Re: Little Stars Day Care
1500 Coors Blvd NW
Traffic Circulation Layout
Architect's Stamp 04-26-2022 (L11-D045)

Based upon the information provided in your submittal received 04-29-2022, the above referenced plan cannot be approved for Building Permit until the following comments are addressed:

TRAFFIC CONTROL LAYOUT - ENLARGED SITE PLAN
1/8" = 1'-0"

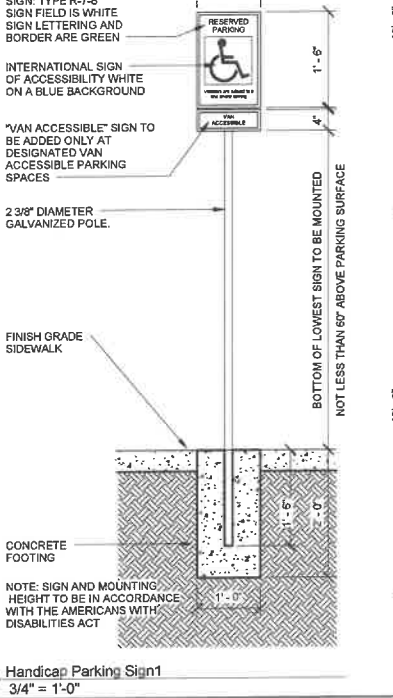
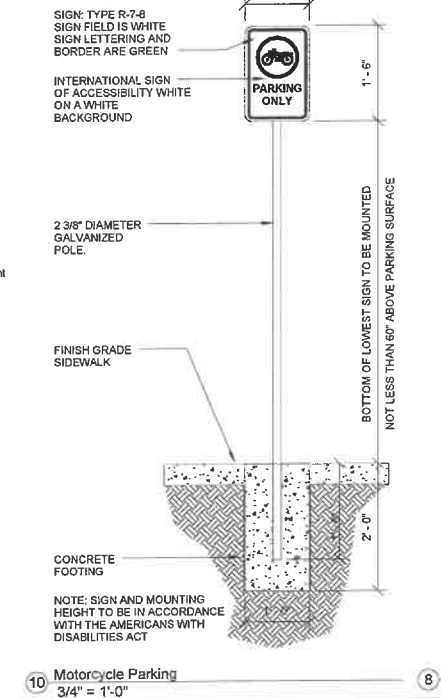
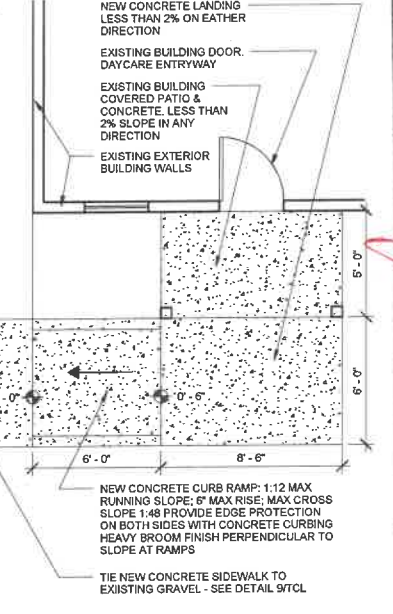
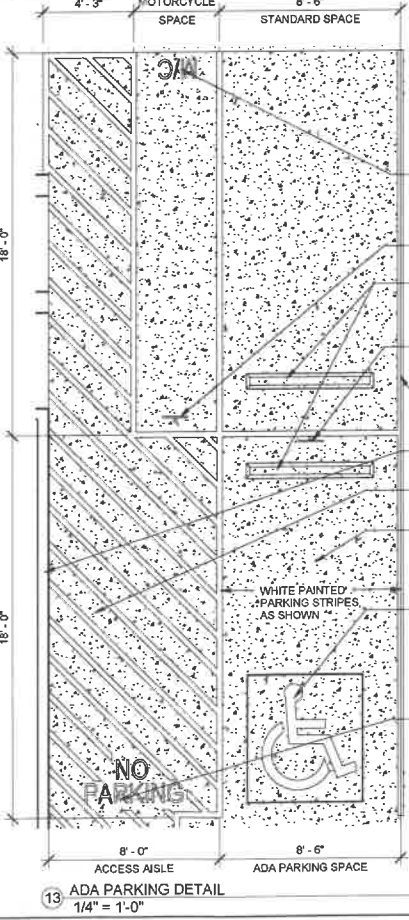
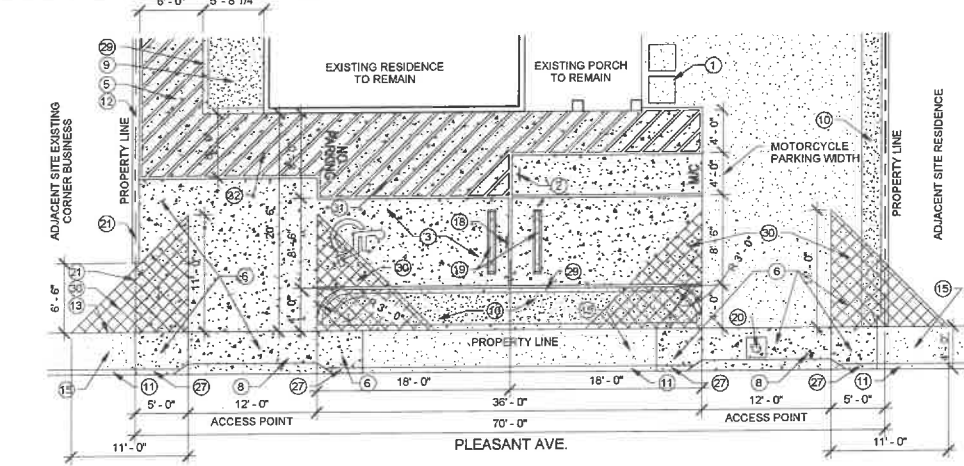
1. Proposed ADA pathway around driveway:

- You will need a Sidewalk Easement for the proposed ADA pathway located outside of COA ROW.
- A Condition of Final C.O. approval:** The approved/recorded Sidewalk Easement be provided to our Transportation Section.

2. Keyed Note 8: Reference COA std dwg 2425B (proposed driveways).

3. Keyed Note 27: Reference COA std dwg 2415A (Std C&G work).

4. The ADA accessible spaces must include an access aisle. The proposed **Van accessible aisle should be 8ft wide** and not 5 ft wide per COA ADA requirements.

5. Motorcycle parking space: Provide proposed stall width.

6. Per DPM, a 6 ft. wide ADA accessible pedestrian pathway is required from the ADA parking stall access aisles to the building entrances. Please clearly show this pathway and provide details. **Shown is 5 width from access aisle.**
